Broadland District Council Response to Examining Authority's Written Questions (ExQ1)

Deadline 1 (6th July 2021)

**KEY TO SYMBOLS**

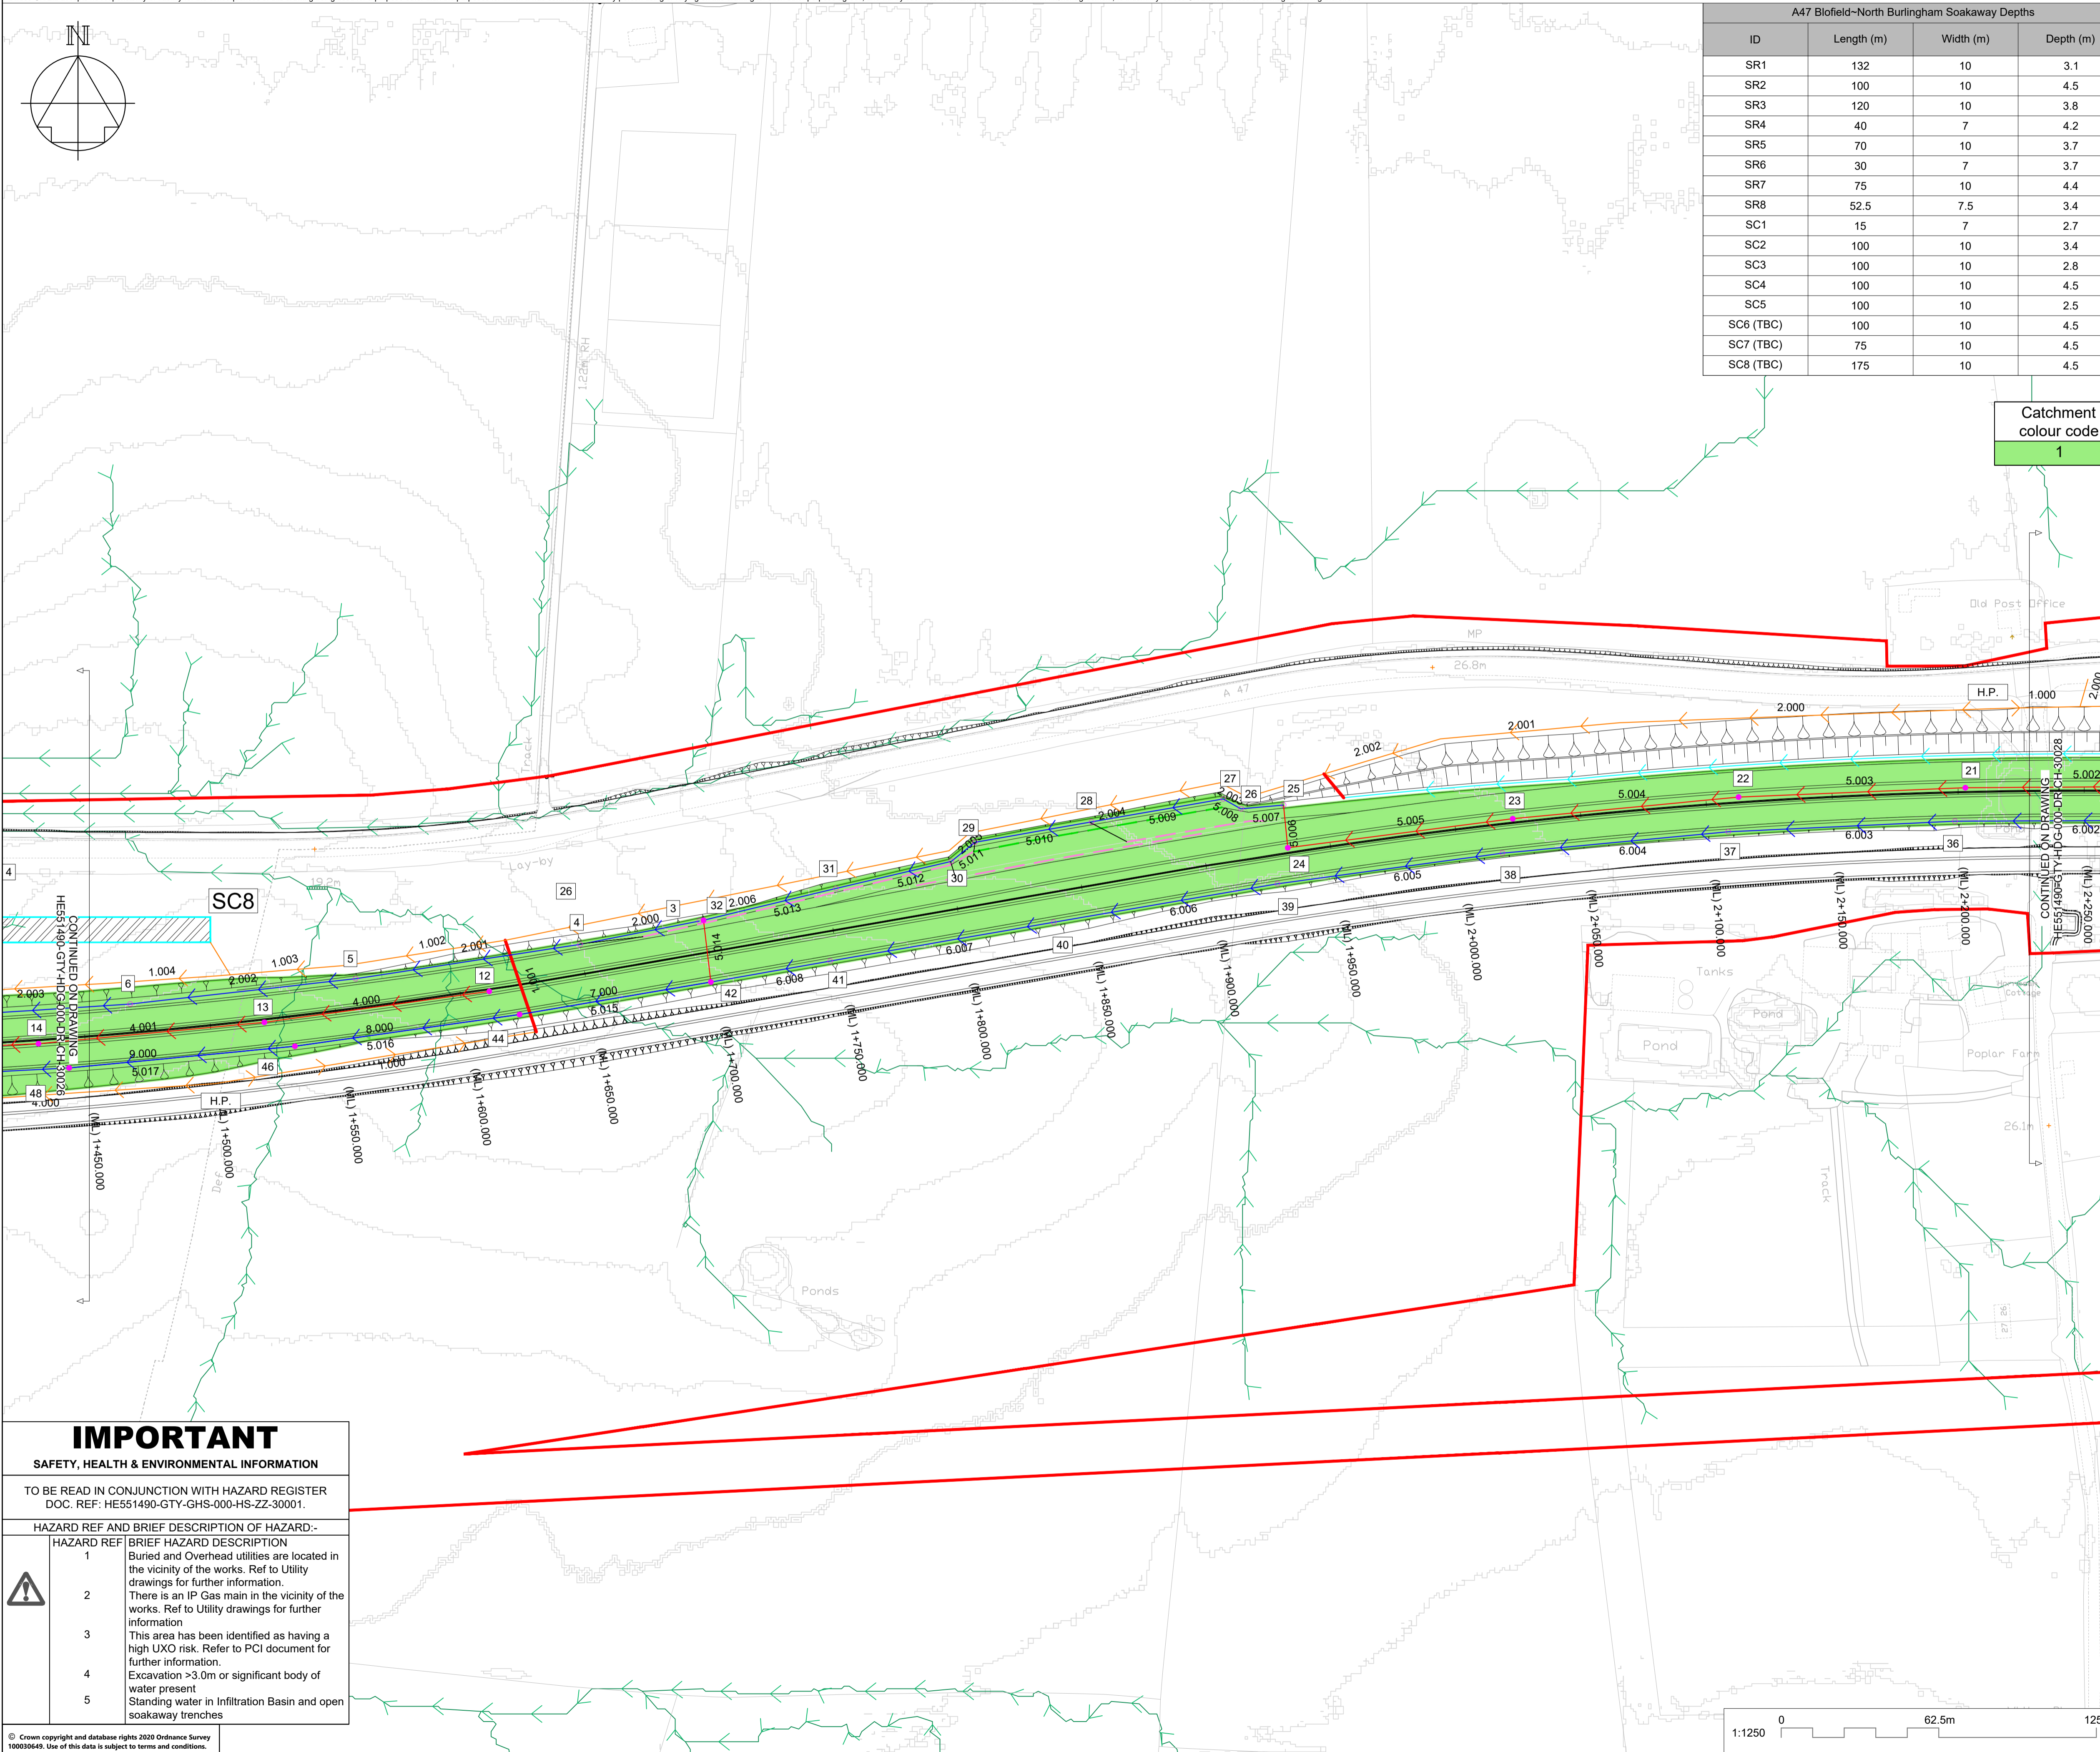
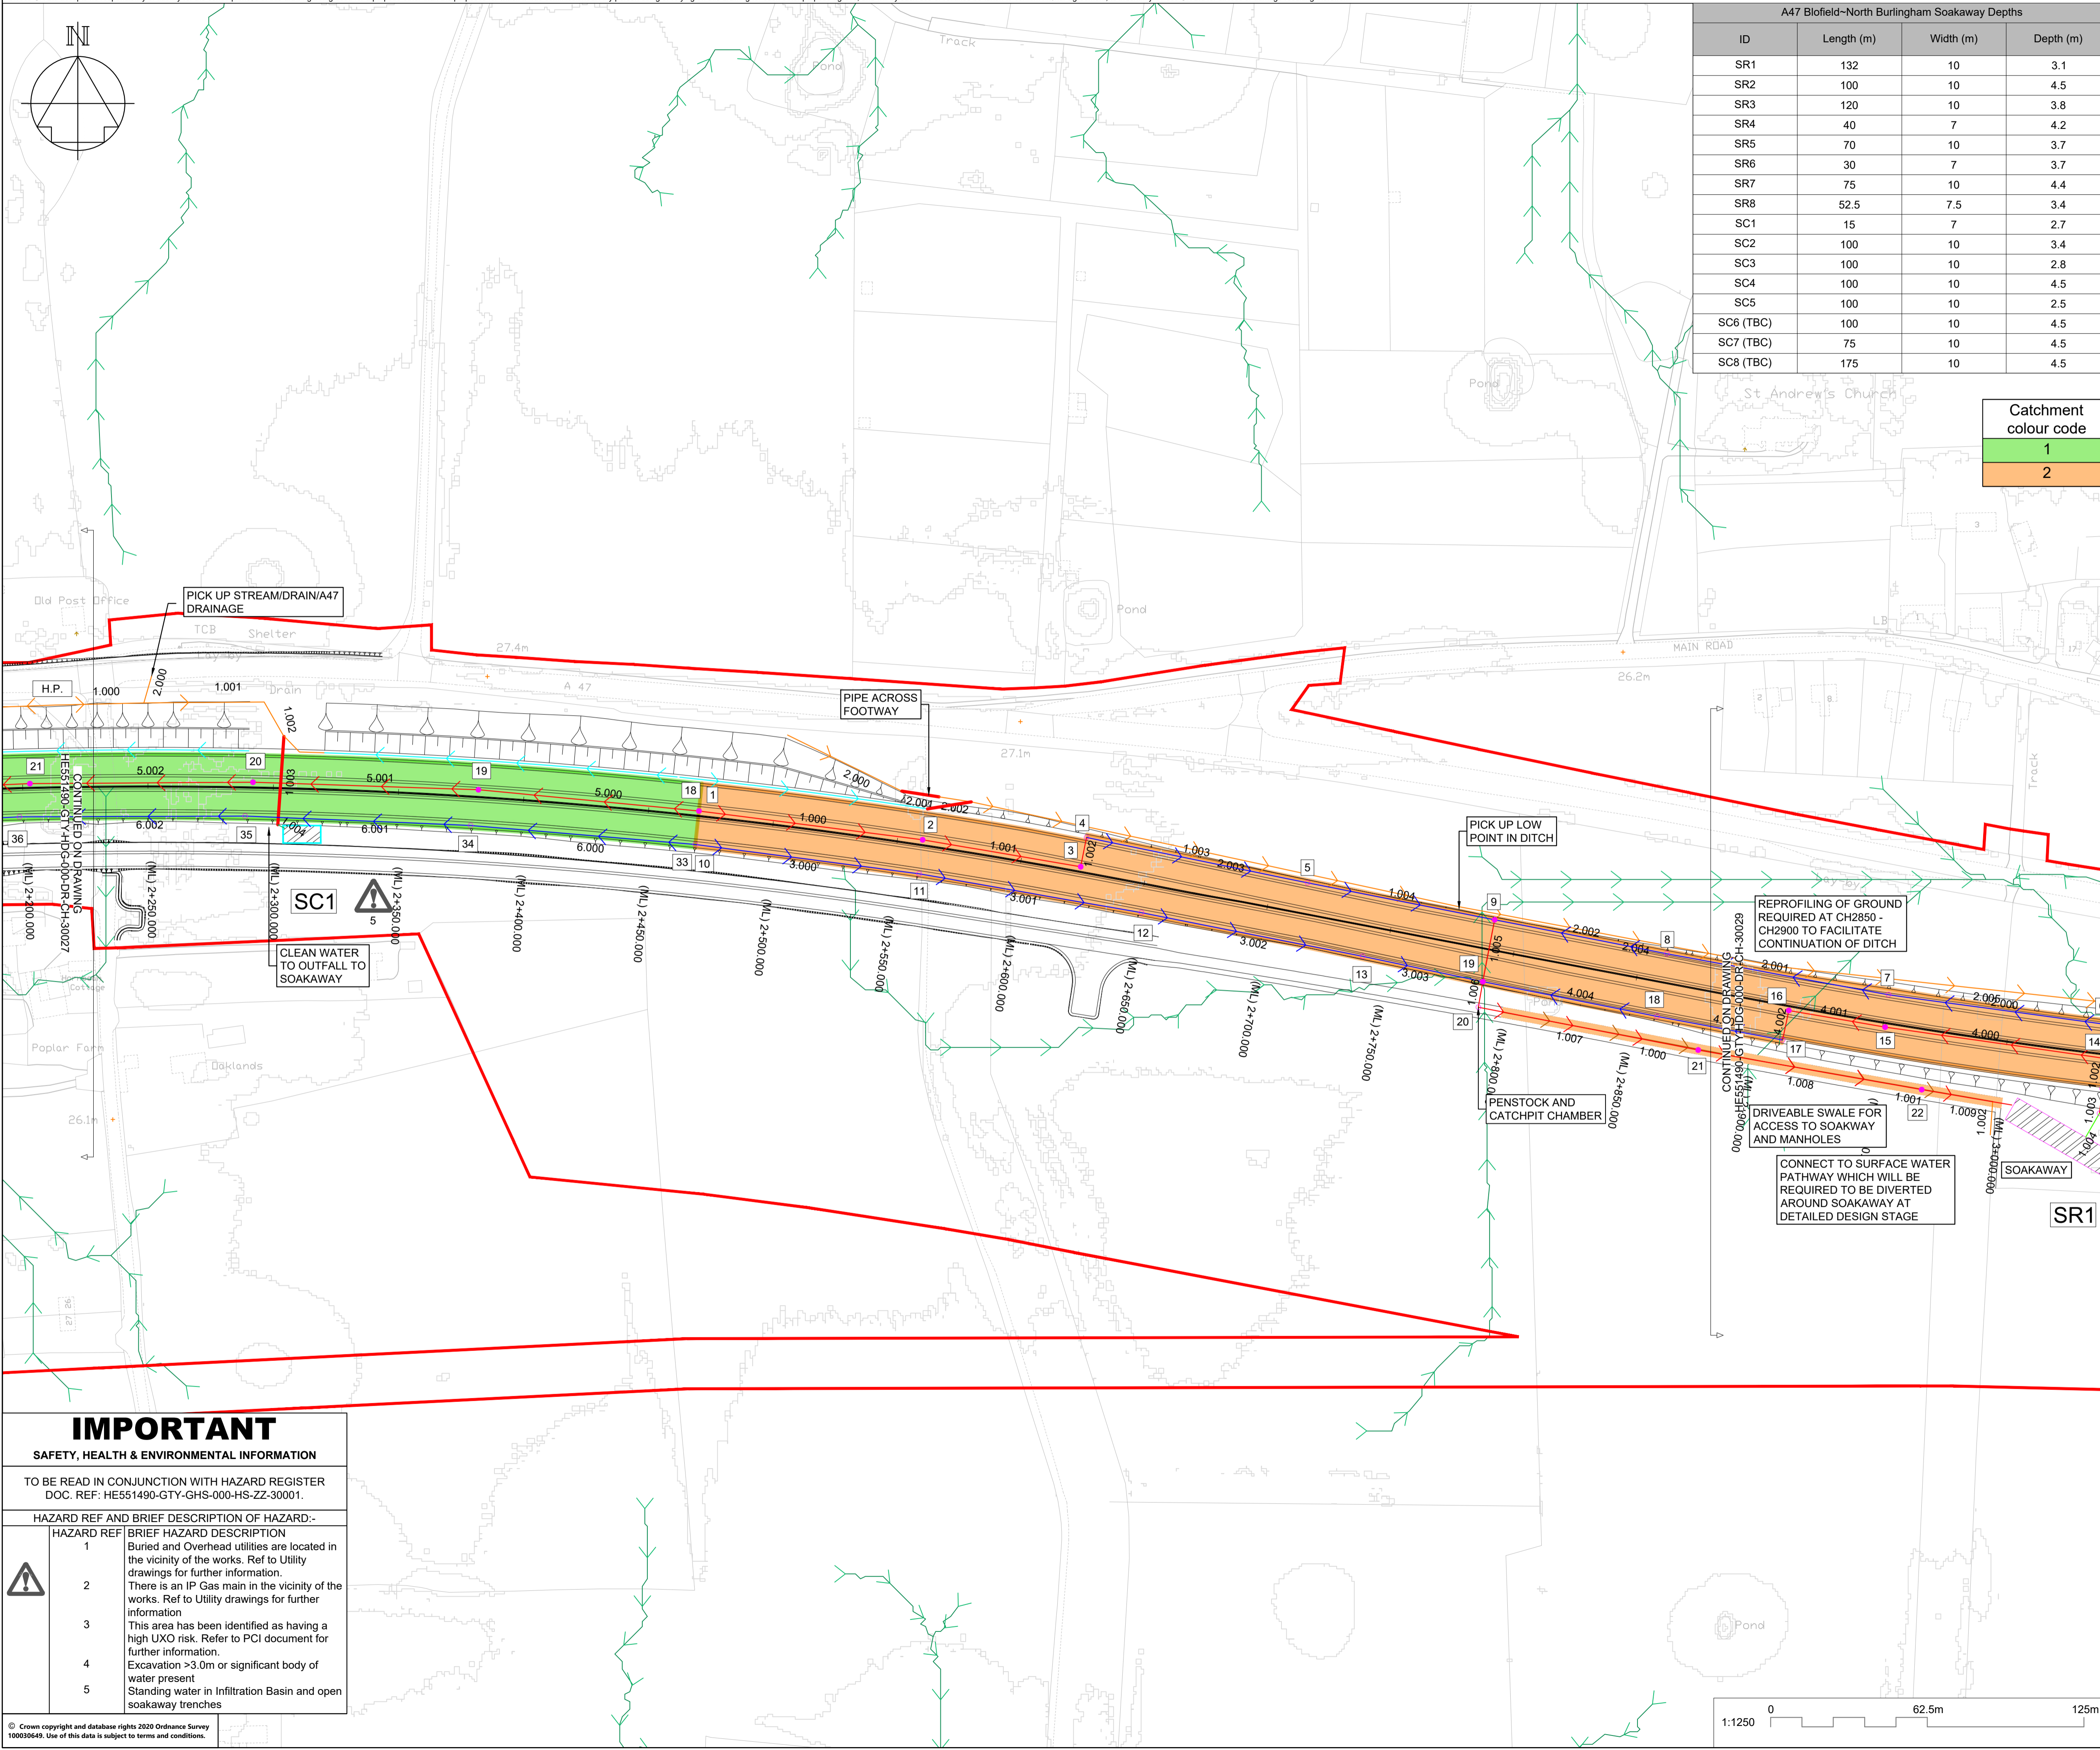
1.15.10	RR [RR-053] raises a concern around potential for increased flood risk to Waterlow Cottage as a result of the Proposed Development. Please provide a response to this concern.	We would endorse the comments from the resident and suggest that the applicant makes personal contact with Mr Trawford to explain the significant drainage proposals here including details of its design performance to hopefully demonstrate that it will operate satisfactorily without a positive outfall and not increase the water table and cause issues at the properties at Waterlow. The soakaway scheme does seem to be close to the eastern boundary of the houses.
